# LIO RESTAURANT AND RETAIL

6 CITY CENTER  
PORTLAND, MAINE

LIFE SAFETY - FIRST FLOOR PLAN

## G1-3

## G1-3

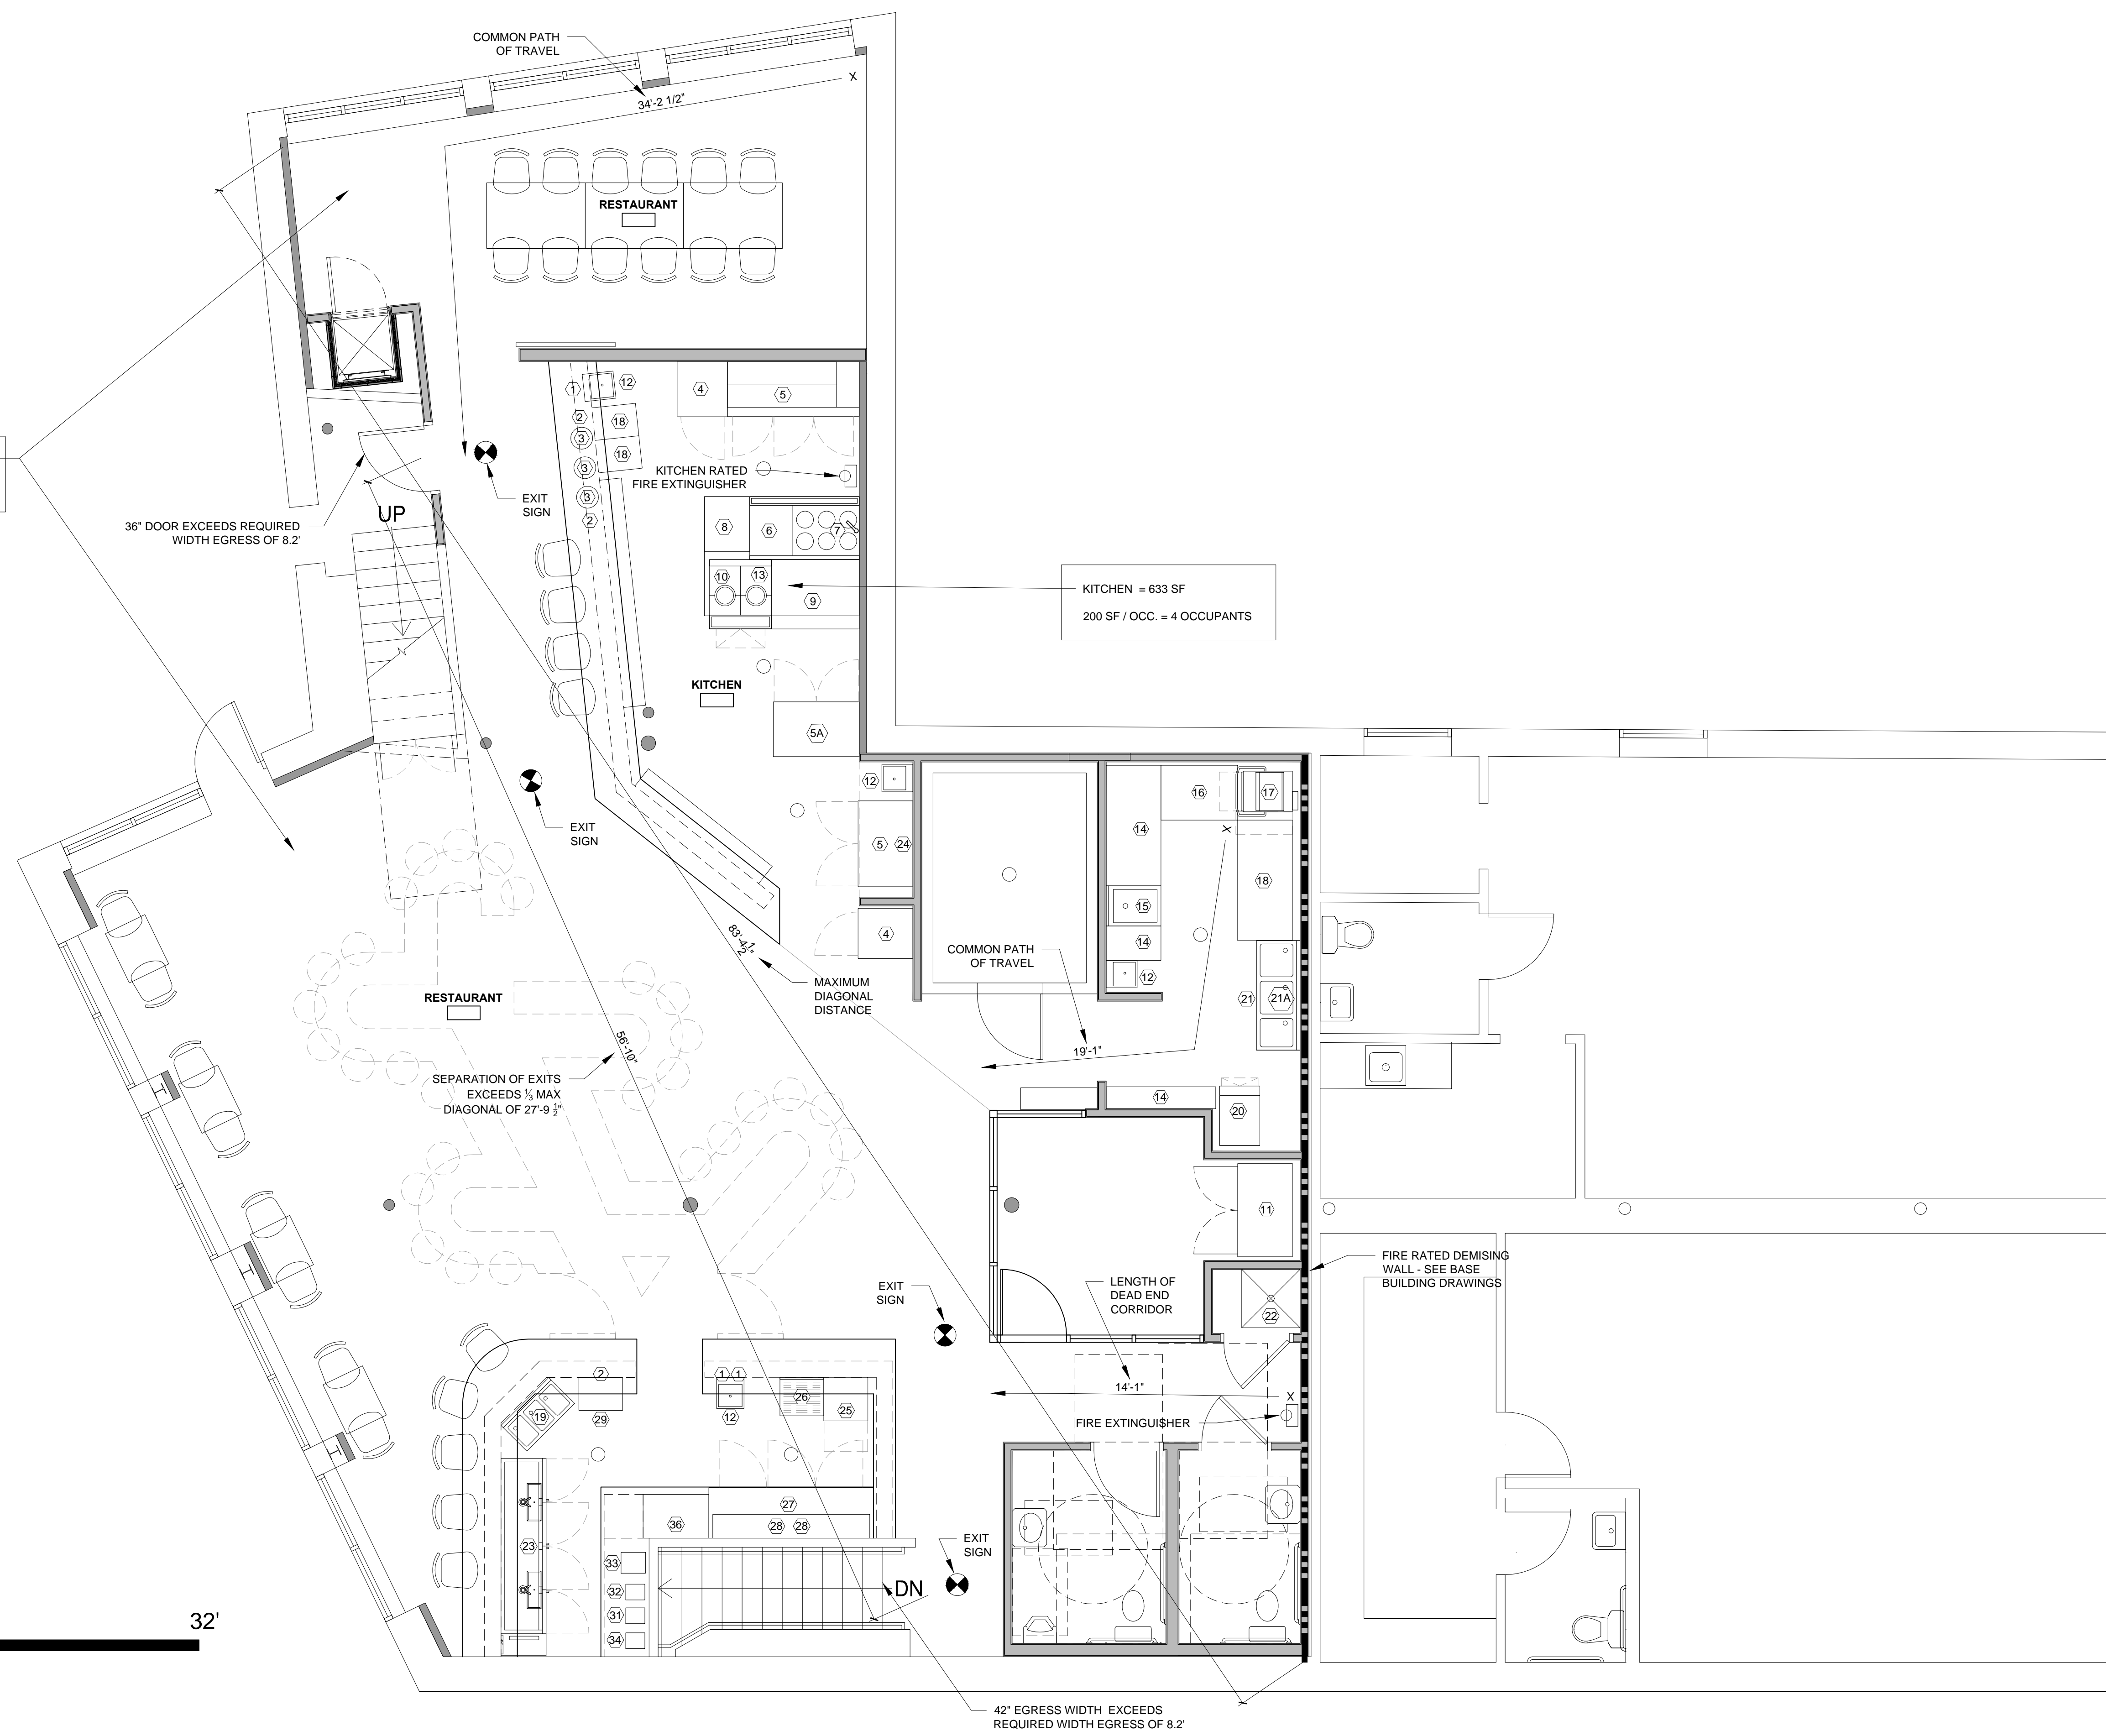
Plan consistency

Confirm if this is a fire rated door, and the plan wall type is NA

Show the access to grade

Will there be seating at this bar?
